Re: Status of Improvement Permit Application #06-5-14134R

On June 21, 2006, an Environmental Health Specialist from the Harnett County Health Department attempted to evaluate your property for the purpose of issuing an Improvement Permit. This individual was unable to evaluate your property for one or more of the following reasons.

Joe West, R. S.
Environmental Health Specialist
Harnett County Department of Public Health

**PLAT SHOWING EASEMENT FOR SEPTIC TANK DISPOSAL FIELD**  
**BEING GRANTED BY MARGERY OVERTON FOR PONDEROSA GOLF CLUB**  
**TO MICHAL PHILLIPS**  
 JOHNSONVILLE TOWNSHIP – HARNETT COUNTY – NORTH CAROLINA  
 SCALE 1"= 100' APRIL 24<sup>TH</sup>, 2006

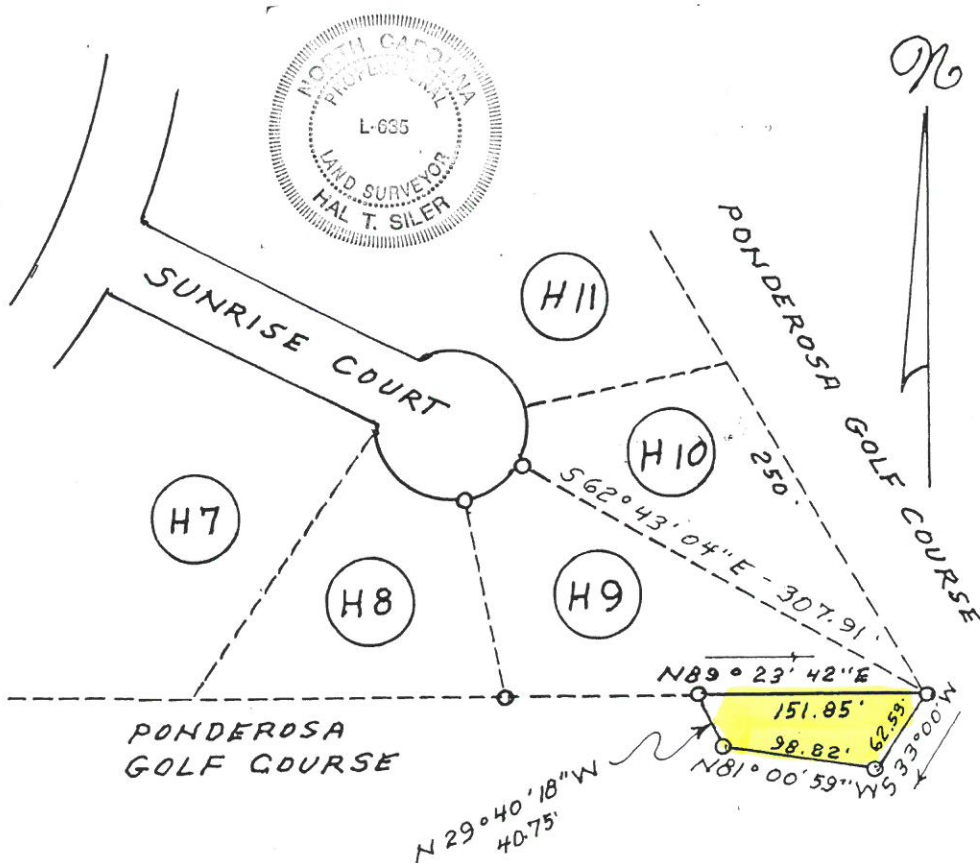
- 1. Property lines/corners not marked or labeled
- 2. House corners not marked or labeled
- 3. Directions not clear to property
- 4. Property needs brush or vegetation removed
- 5. Backhoe pits required
- 6. Other – Please submit to Central Permitting plot plan that shows your septic easement.
